**From:**jose@mayorgacharteredarchitect.com  
**Sent:**Tue, 26 Jan 2021 12:34:17 -0000  
**To:**Planning  
**Cc:**  
**Subject:**FAO Julie Parry Ref 65 Lime Kiln Lane, Holbury  
**Attachments:**cil\_questions.pdf

PROPOSED ELEVATIONS

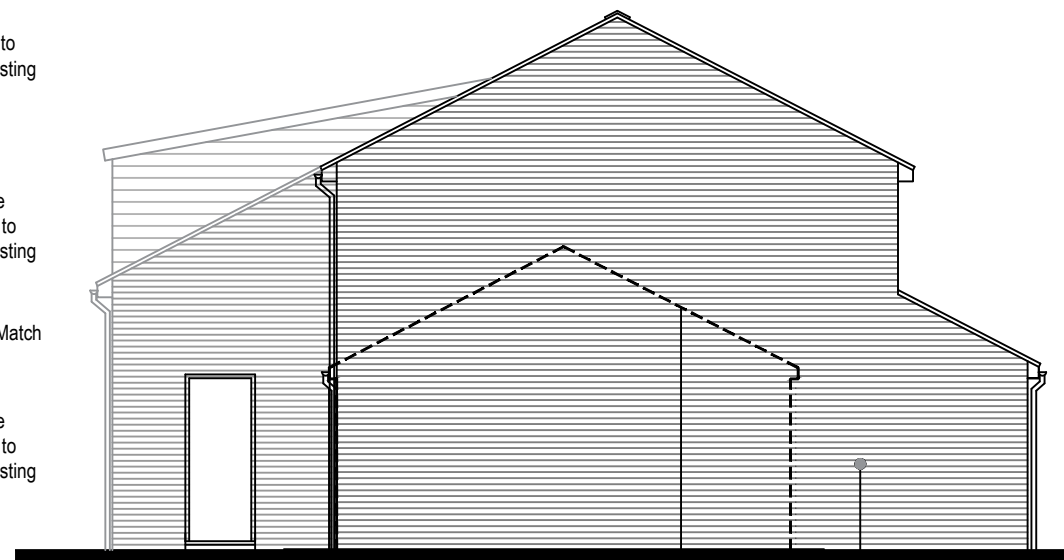
1  Yes Please feel free to change the Description. Although the Garage is existing so an extension over Garage would also be appropriate. I also note the additional footprint in front of the Garage at single storey.

This would create a degree of subservience with a setback first floor as the existing condition of the main dwelling.

3 - My client would welcome your thoughts on creating a subservient element here. Perhaps a stepdown on the roof form to address subservience.

If you are mindful to accept this I would be happy to amend the drawings to suit accordingly?

PROPOSED FLOOR PLANS

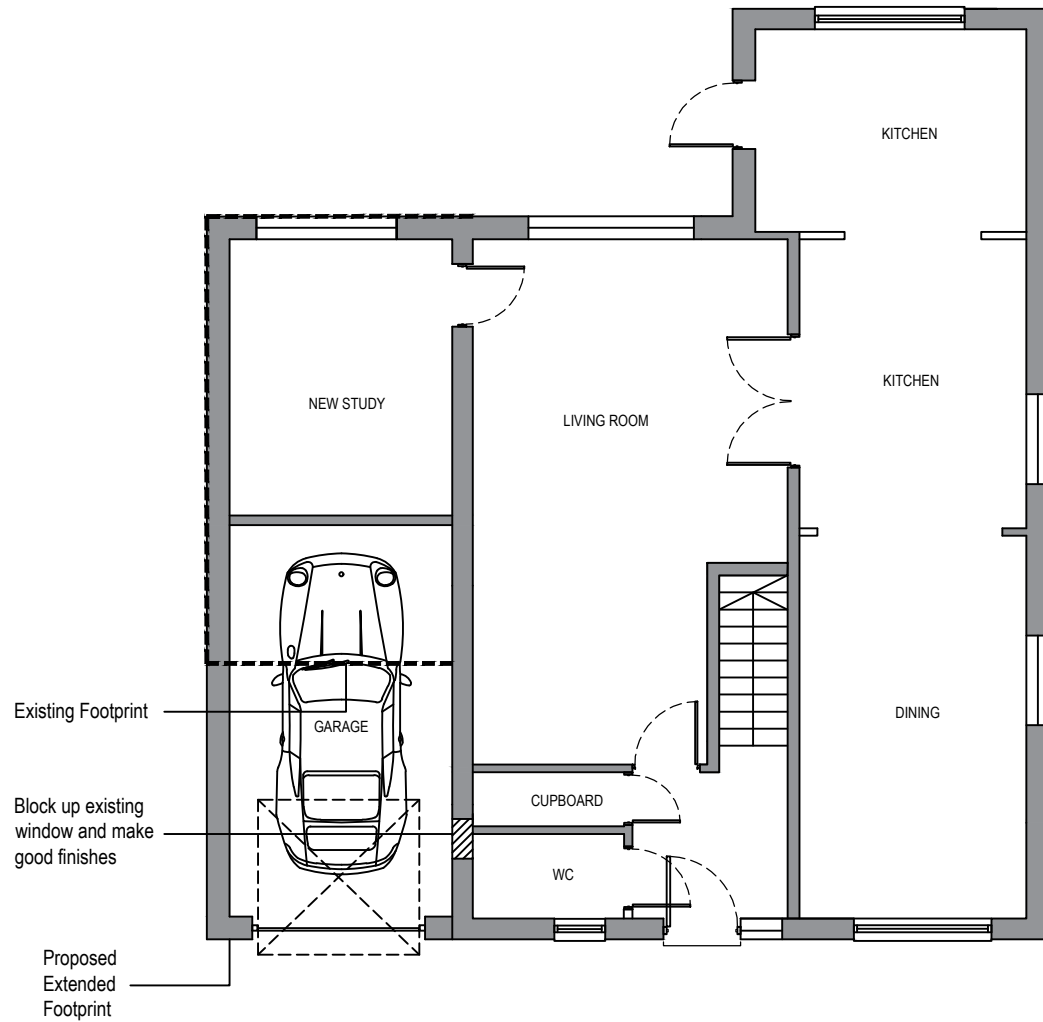
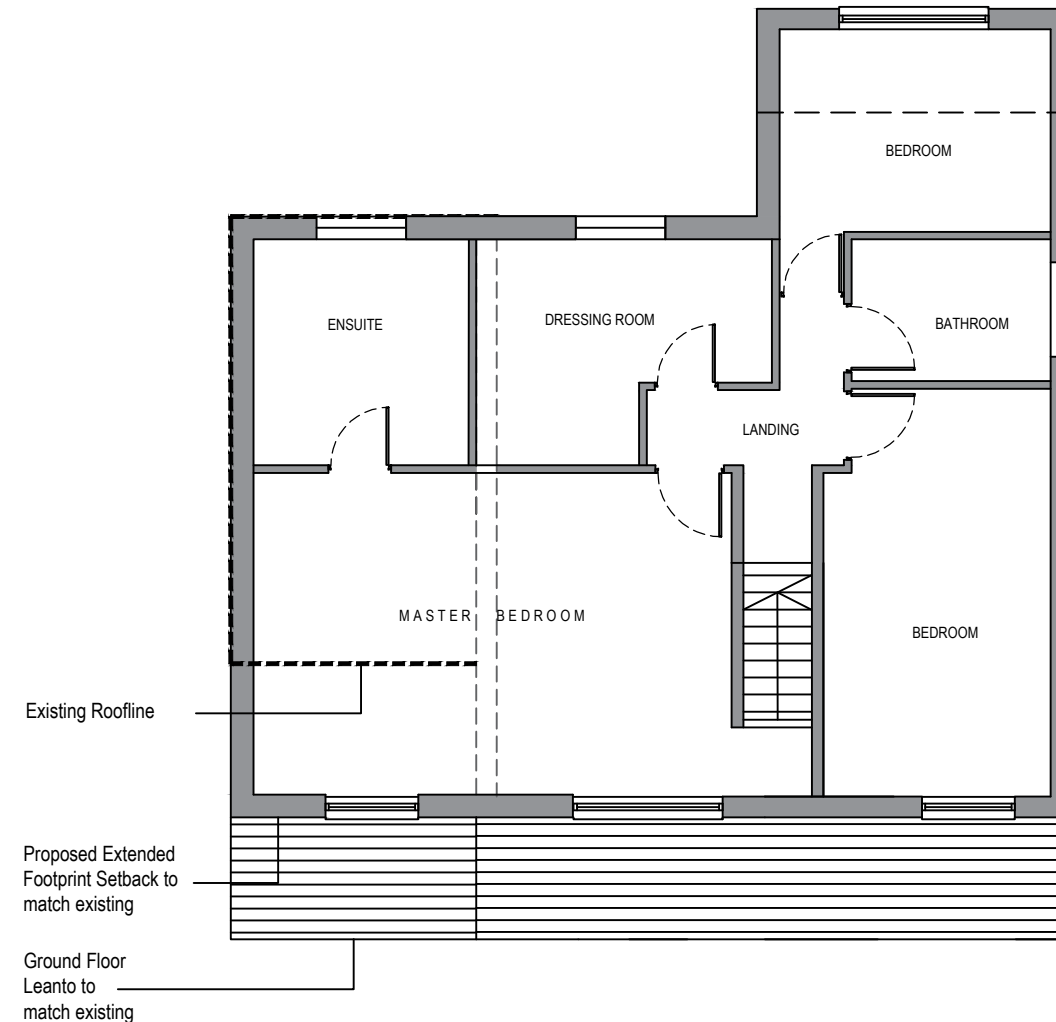
2  The single Storey Extension is within the boundary of the site. My client is a builder and has assured the Foundations will not oversail into the highway. The proposed Wall will be within his ownership.
